**KIRKLEES METROPOLITAN COUNCIL
DEVELOPMENT & MASTER PLANNING SERVICE**

**DELEGATED DECISION FOR PRIOR APPROVAL FOR CHANGE OF USE
FROM COMMERCIAL, BUSINESS AND SERVICE USES TO
DWELLINGHOUSES**

Reference no. 2023/CL/92836/W

**Site Address 1st & 2nd floors, 9-13, Market
Walk, Huddersfield, HD1 2QA**

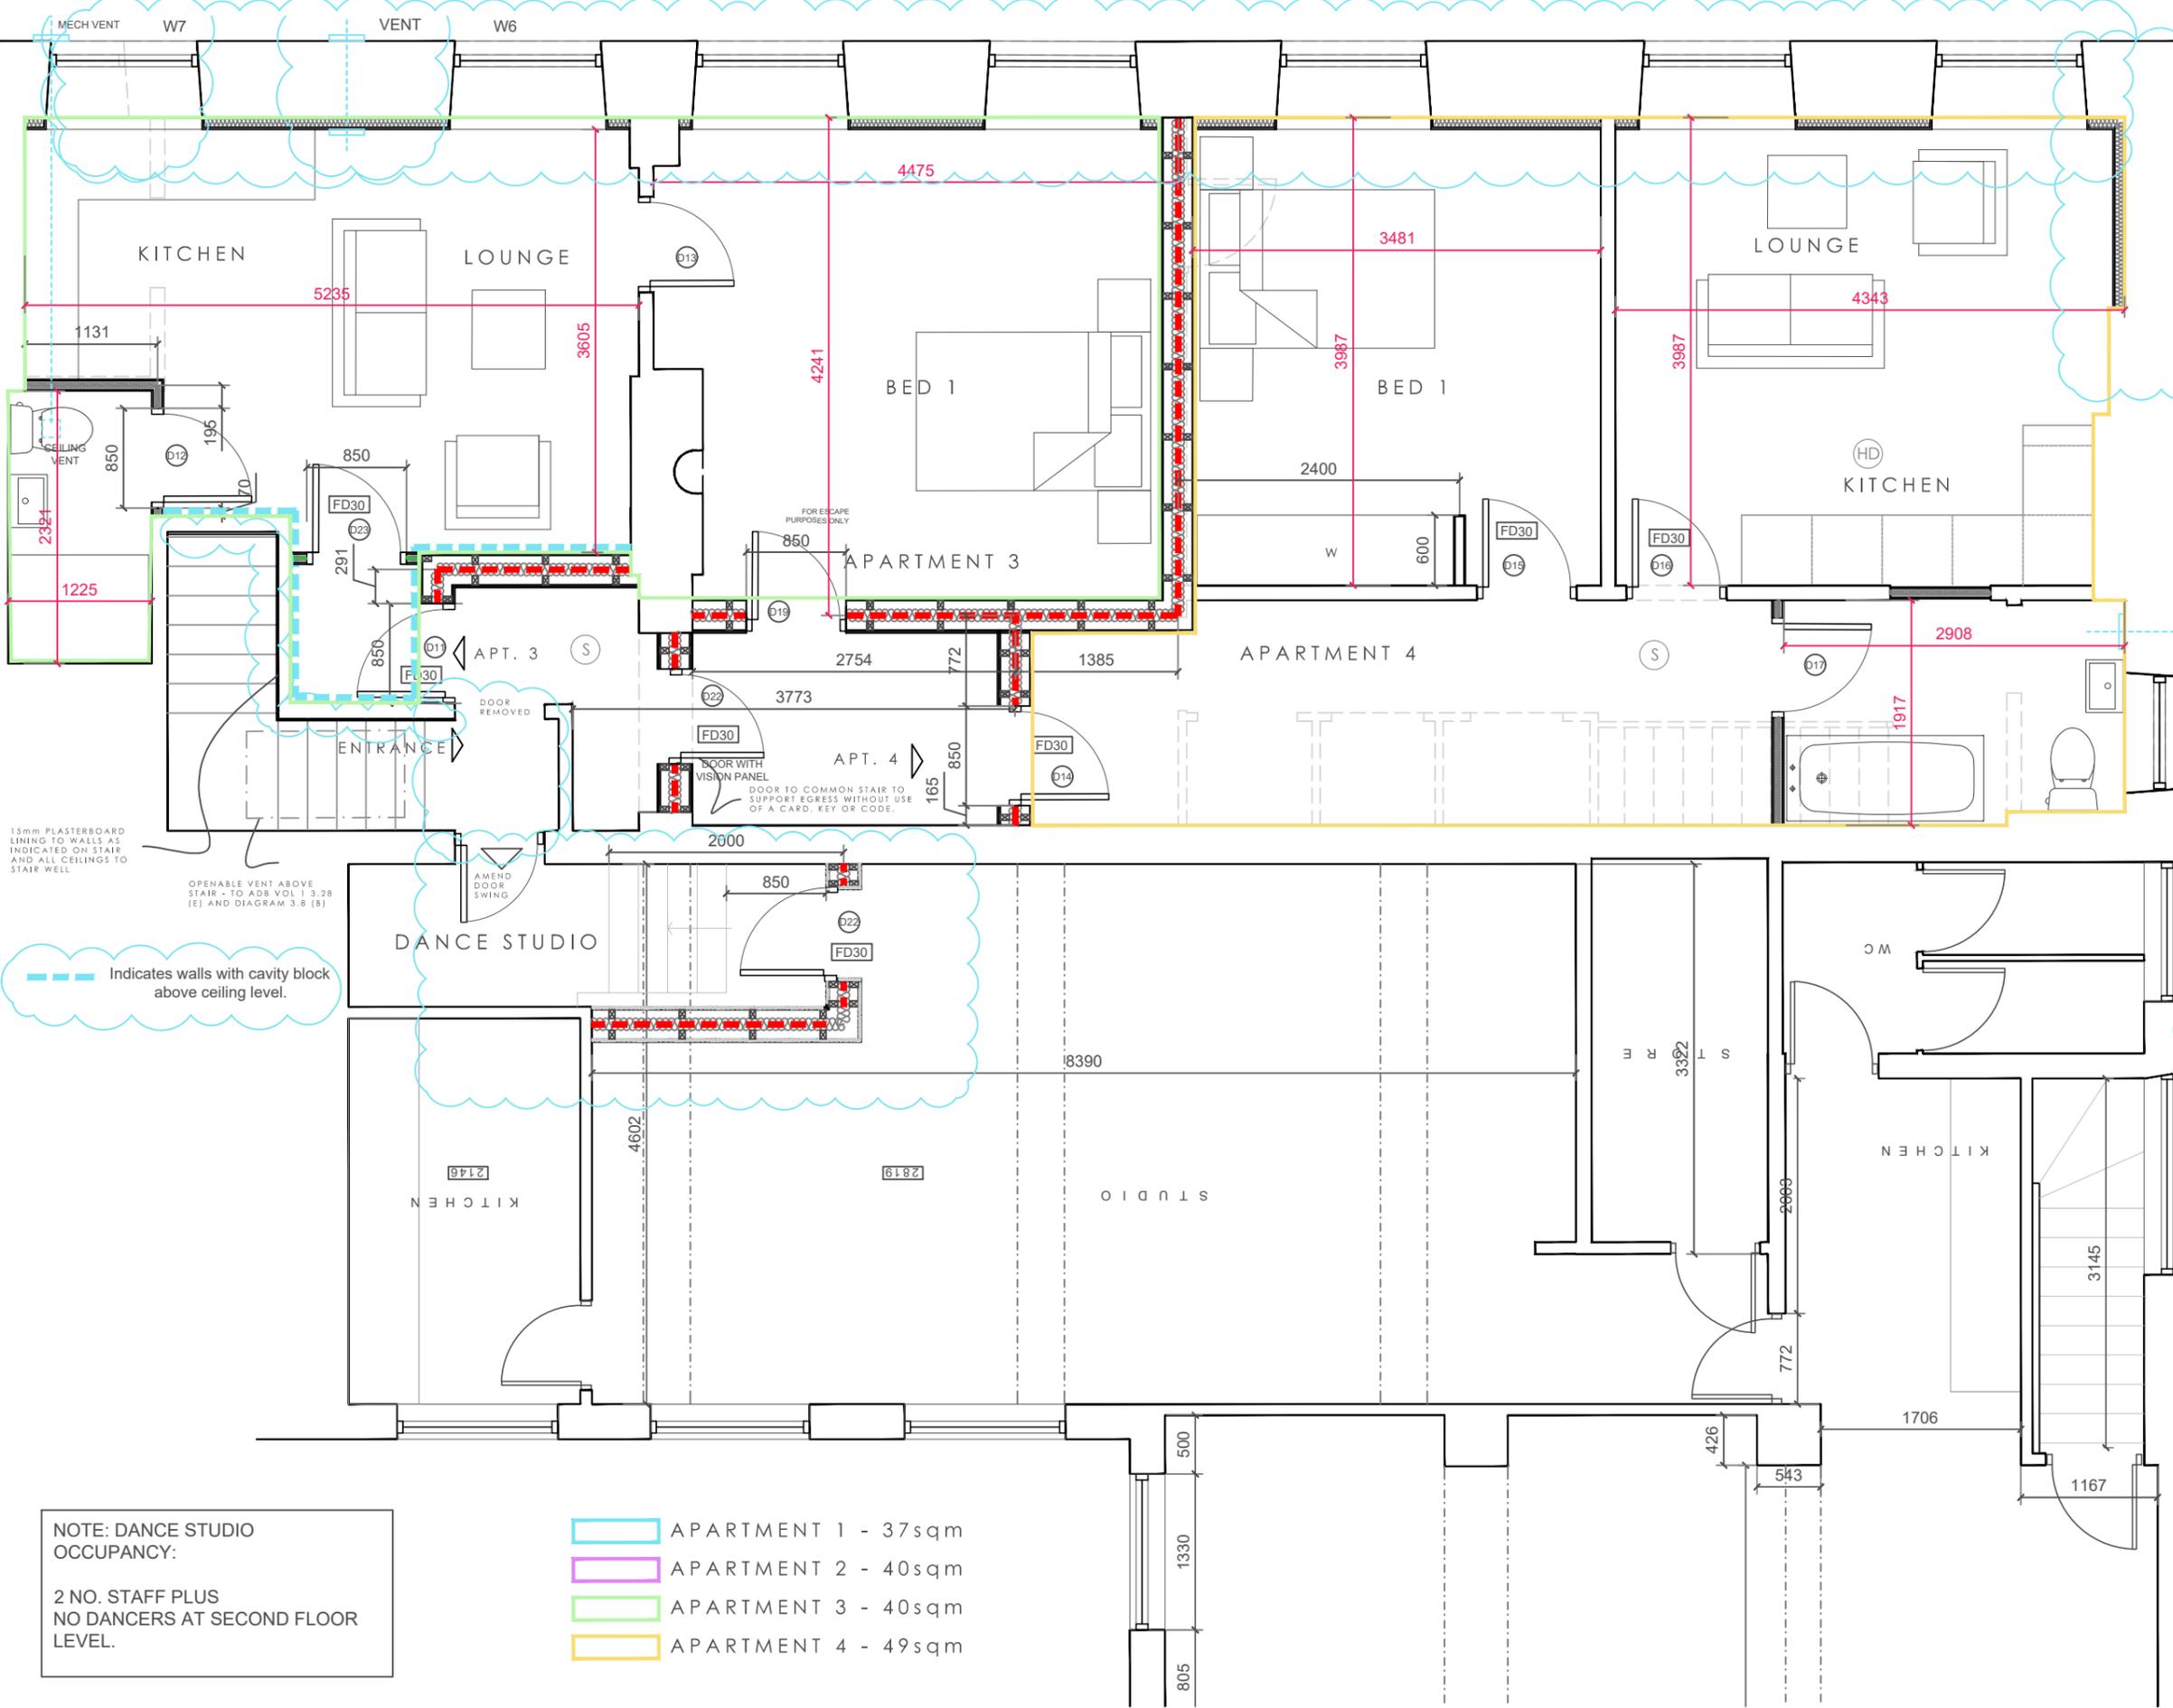
Apartment 3 is proposed to be a one bedroom second floor flat. The Technical Housing Standards document states that a one-bedroom flat for one person (minimum assessed) one storey should be at least 37 or 39 square metres dependant on whether the bathroom has a shower. In this instance, the internal accommodation is proposed to approximately 33.6 square metres which would not accord with the recommended space standards. However, the bedroom is shown to sleep two persons which requires 50 square metres of space, thus contrary to space standards.

Apartment 4 is proposed to be a one bedroom second floor flat. The Technical Housing Standards document states that a one-bedroom flat for one person (minimum assessed) one storey should be at least 37 or 39 square metres dependant on whether the bathroom has a shower. In this instance, the internal accommodation is proposed to approximately 41.3 square metres which would not accord with the recommended

space standards. However, the bedroom is shown to sleep two persons which requires 50 square metres of space, thus contrary to space standards.

The application has not been submitted with sufficient information to allow the Local Authority to assess the noise impacts. It is also considered that the internal gross floor space of Apartments 1, 2, 3 & 4 would not meet the space standards for the two double bed spaces proposed, therefore the application is to be refused.
